Recommendation Report for Planning Permission for Works or Extension to a Dwelling

REF NO: AW/72/22/HH

LOCATION: 4 Elizabeth Avenue
 Aldwick
 PO21 3EL

PROPOSAL: Single storey rear extension.

**P**roposed Extension and Alterations  
at 4 Elizabeth Avenue, Bognor Regis  
for Mr and Mrs A Dennis  
Drawing P10 March 2022 Scale 1:100 @ A3  
Proposed Drawing - Floor Plan, Roof Plan & Elevations

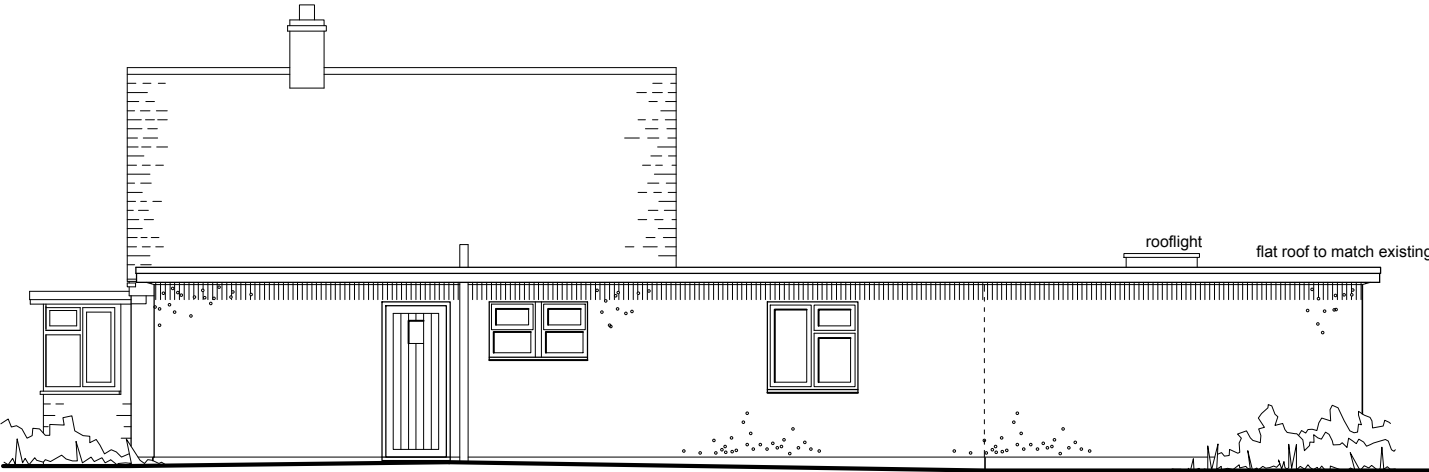
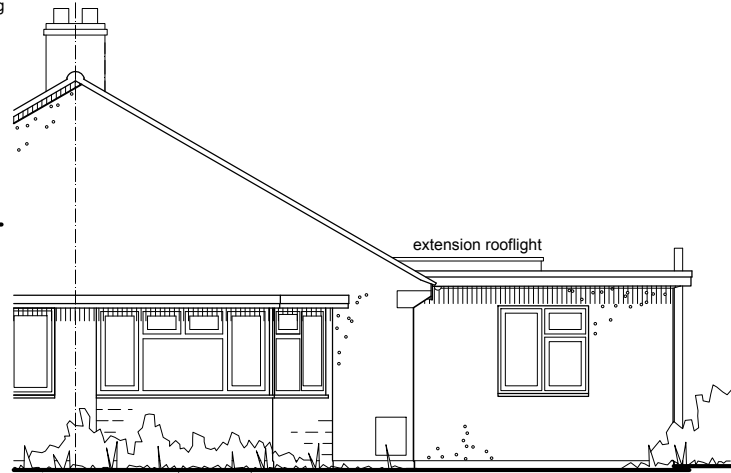
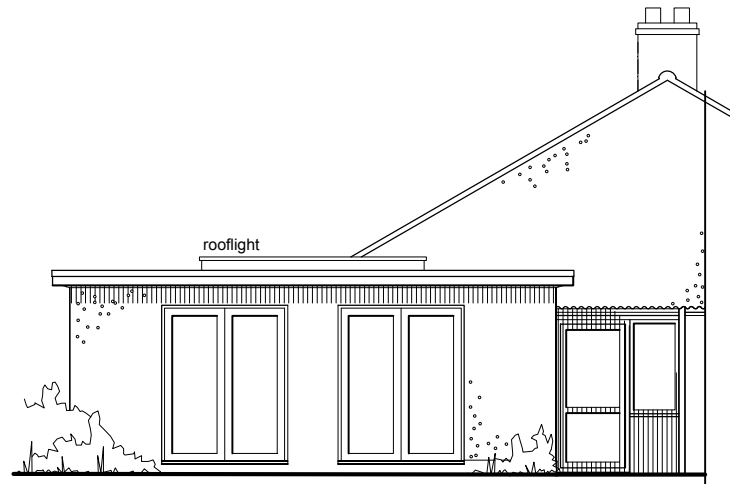
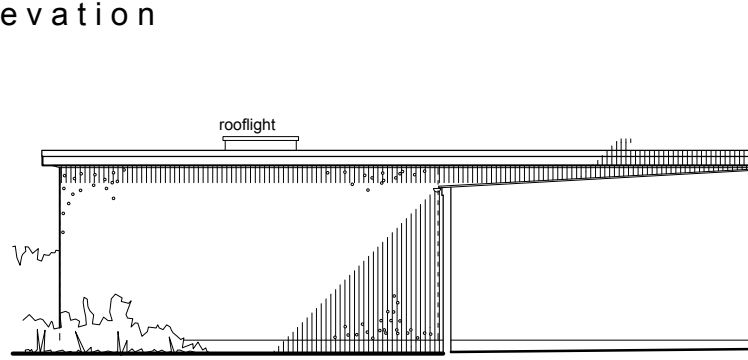
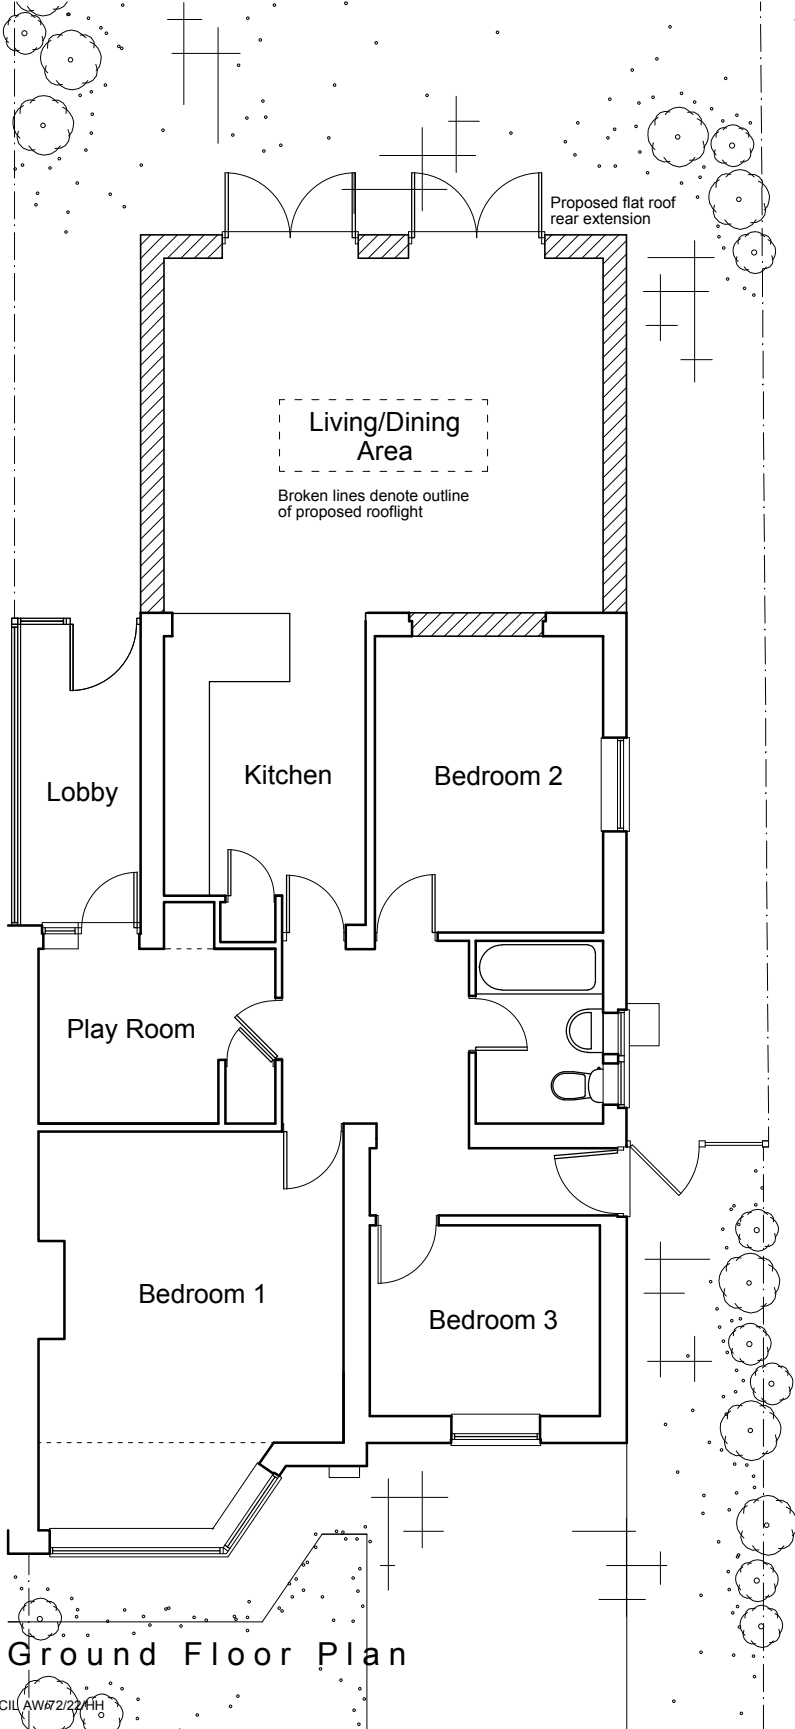
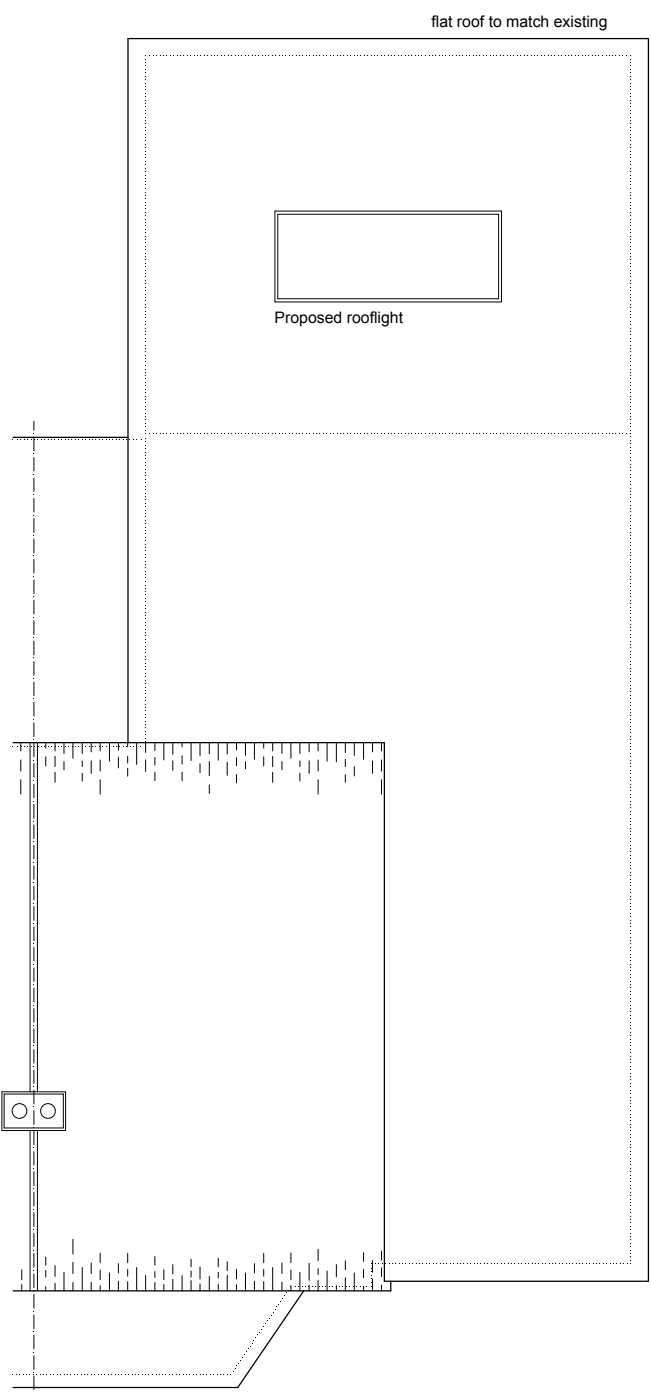
The property is a gable roofed semi-detached bungalow, with an existing flat roof wrap around extension. The proposal will extend from the rear elevation of this extension by a depth of 5m and will retain the existing width of approximately 6.45m. It is a modest size, and will have a flat roof, connecting to and matching that of the existing flat roof. This will integrate sympathetically with the host and will ensure minimal impact on the visual appearance of the property. The proposal follows the design of the existing and is in keeping with the character of the property, and the locality, and will have little harm on visual amenity. Being to the rear, the proposal will not be visible from the street scene and will have no impact on the composition or appearance of the street scene.

The proposal is single storey and will have a flat roof at a height of 2.7m, lining up with the existing roof of the host. This new roof will incorporate a rooflight, which will protrude slightly above at approximately 2.87m and will have no impact on residential amenity. 1.6m will be retained to the north boundary, 18.1m to the east, and 1.8m to the south. These distances are acceptable and accord with D DM4 of the Arun Local Plan. The proposal does not conflict the 60 degree line when taken from the windows of both

The extension features two sets of French doors to the east (rear) elevation, and the installation of a new window to the south. The French doors to the rear will overlook the garden and pose no risk of harm to residential privacy or amenity, being situated a sufficient distance from any neighbouring properties. The window to the south will face No.5 but will not unduly overlook this neighbour. Given its scale, it poses minor risk of harm to their residential privacy and amenity, and as such is acceptable.
